Lead Local Flood Authority
Post Point CHN 215
Hertfordshire County Council
County Hall, Pegs Lane
HERTFORD SG13 8DN

Date 26 April 2022

RE: 6/2021/2260/FULL – Shell Welwyn Garden City, Stanborough Road, Welwyn Garden City, AL8 6XA

- Welwyn Garden-12038629-PLG-PSDL-21 Proposed Schematic Drainage Layout
- Welwyn12038629-ASB-PPG21-17 Drainage Drawing

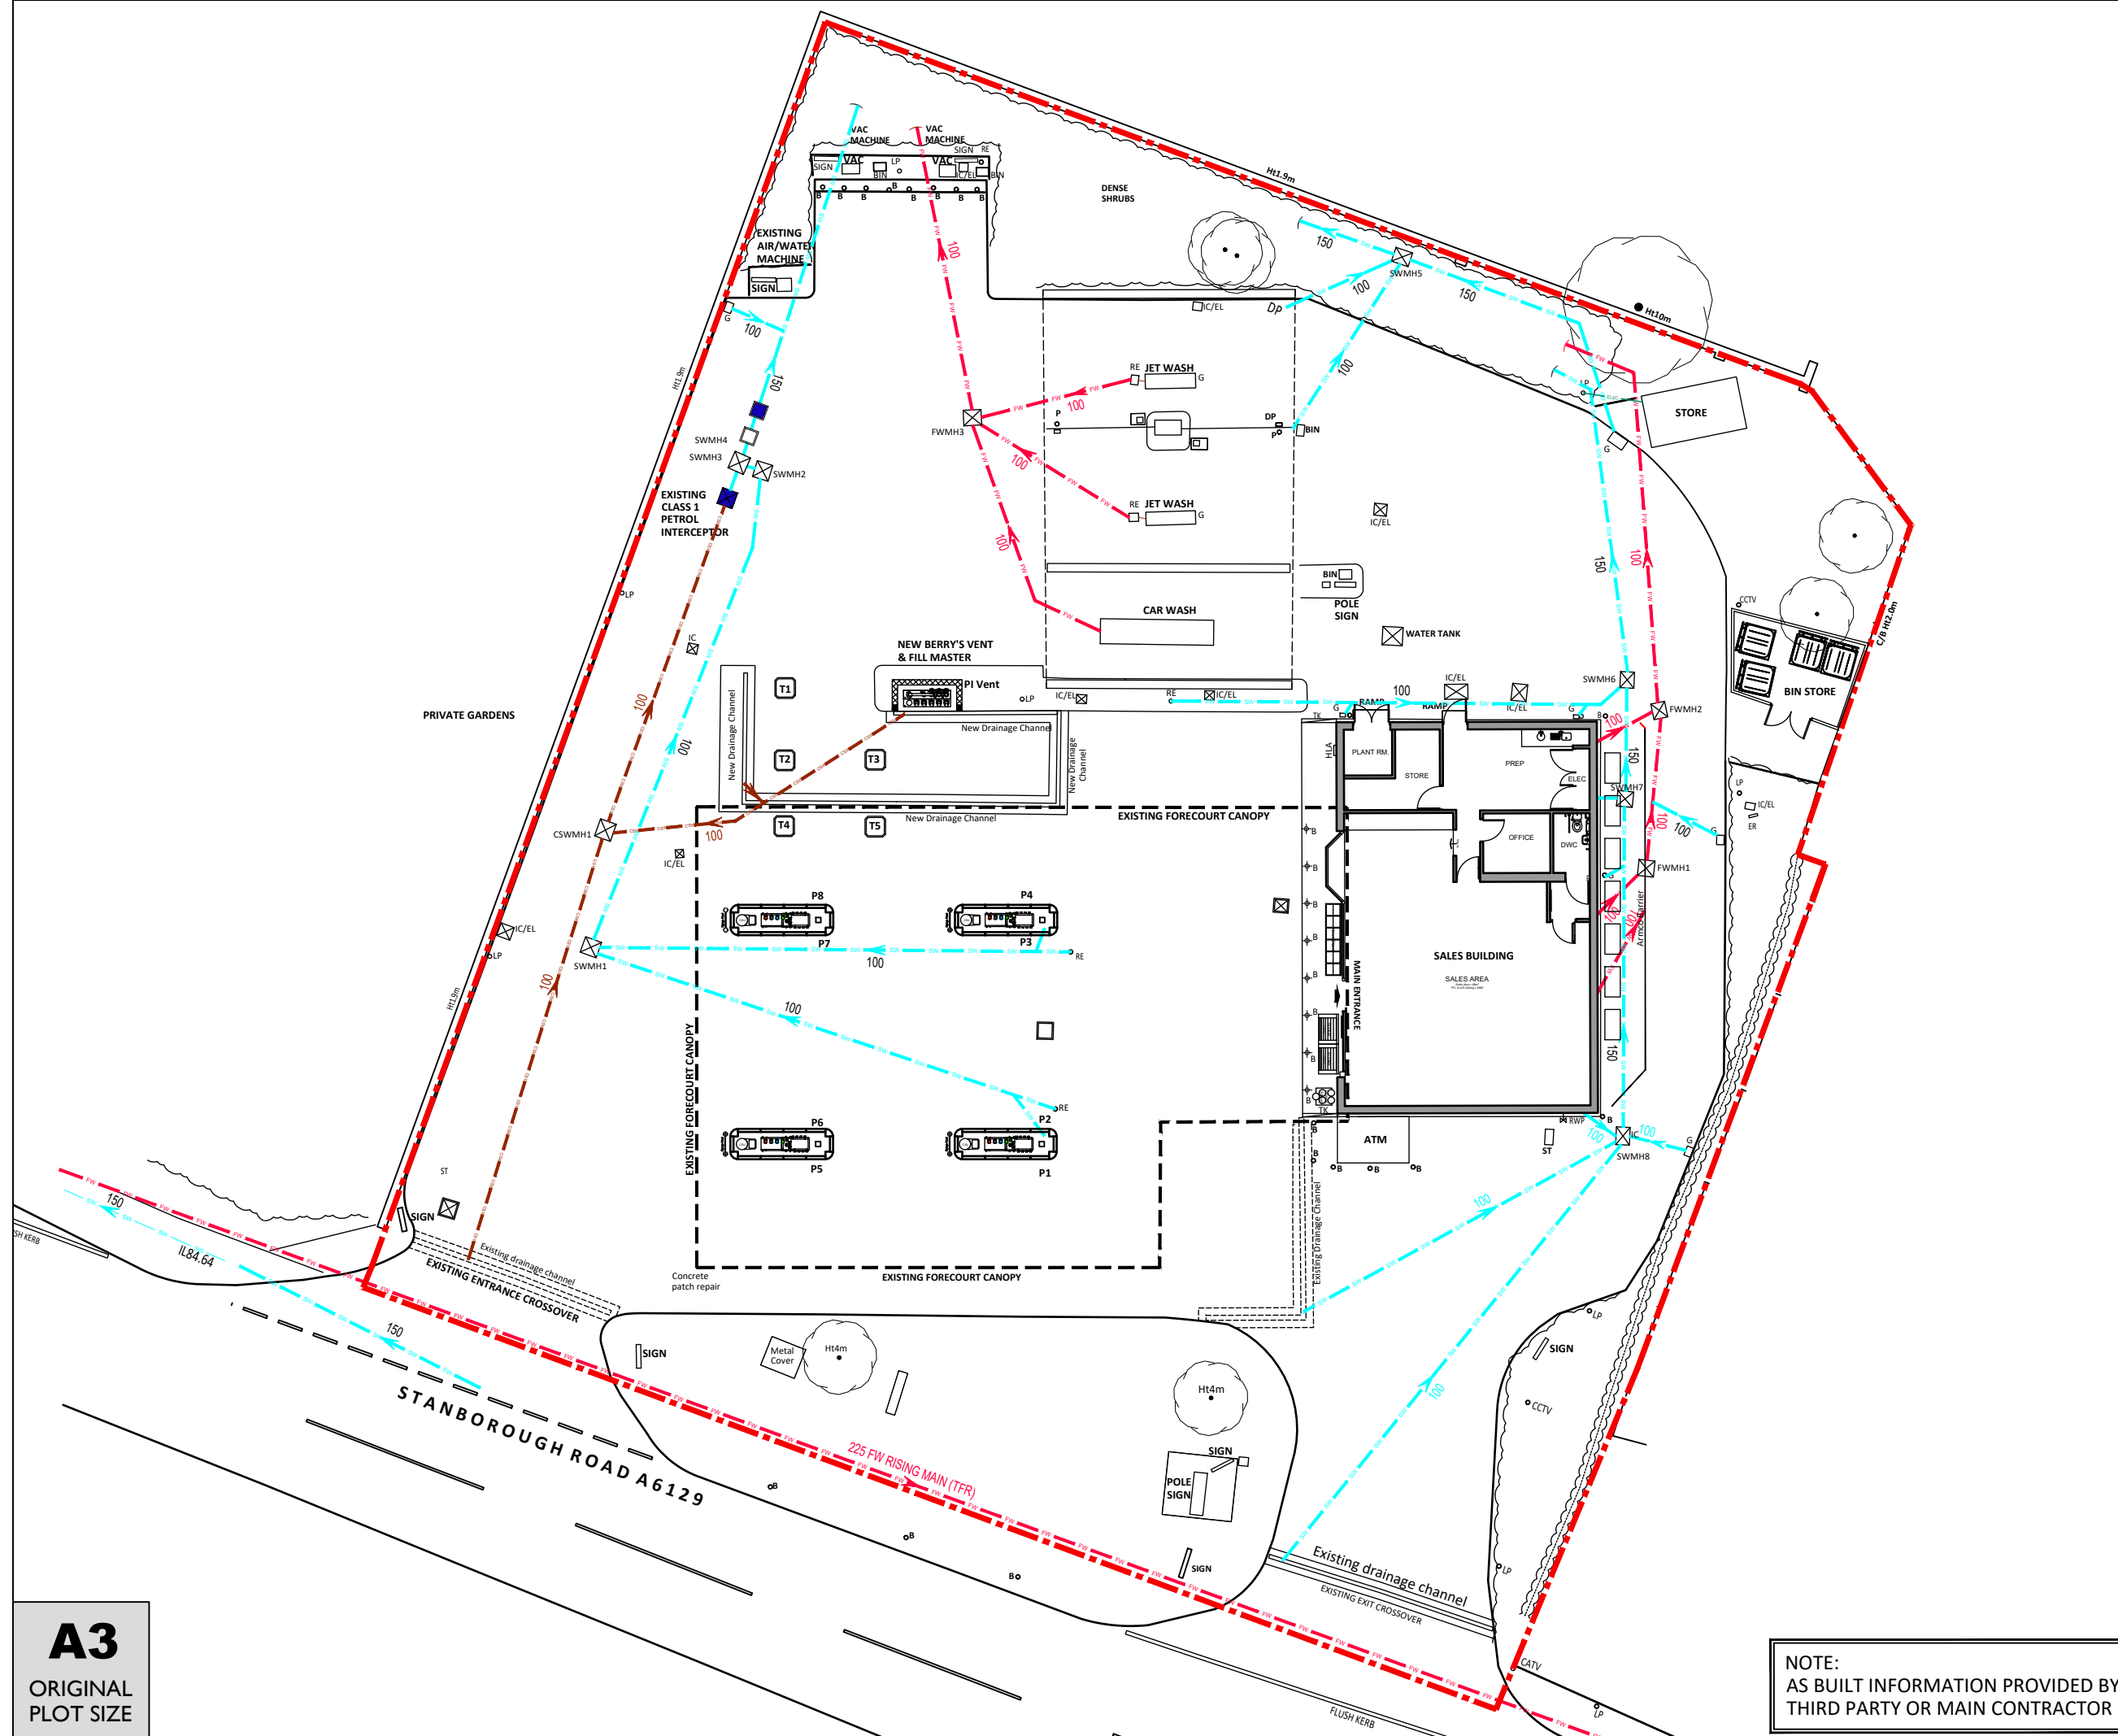
The drainage strategy is based on discharge into the combined Thames Water sewer. However, no further details have been provided regarding the scheme. As minimum we

require the applicant to provide a suitable discharge location, discharge rate and provision of attenuation storage volume for the 1 in 100 year plus climate change event. We would expect the site to discharge at the lowest practicable rate into the sewer.

The applicant is also proposing to discharge into a combined sewer therefore we would advise the applicant to contact Thames Water to ensure they are satisfied with the proposed scheme. We note that hardstanding area should discharge to foul however where possible clean roof run-off should be discharged to surface water sewer.
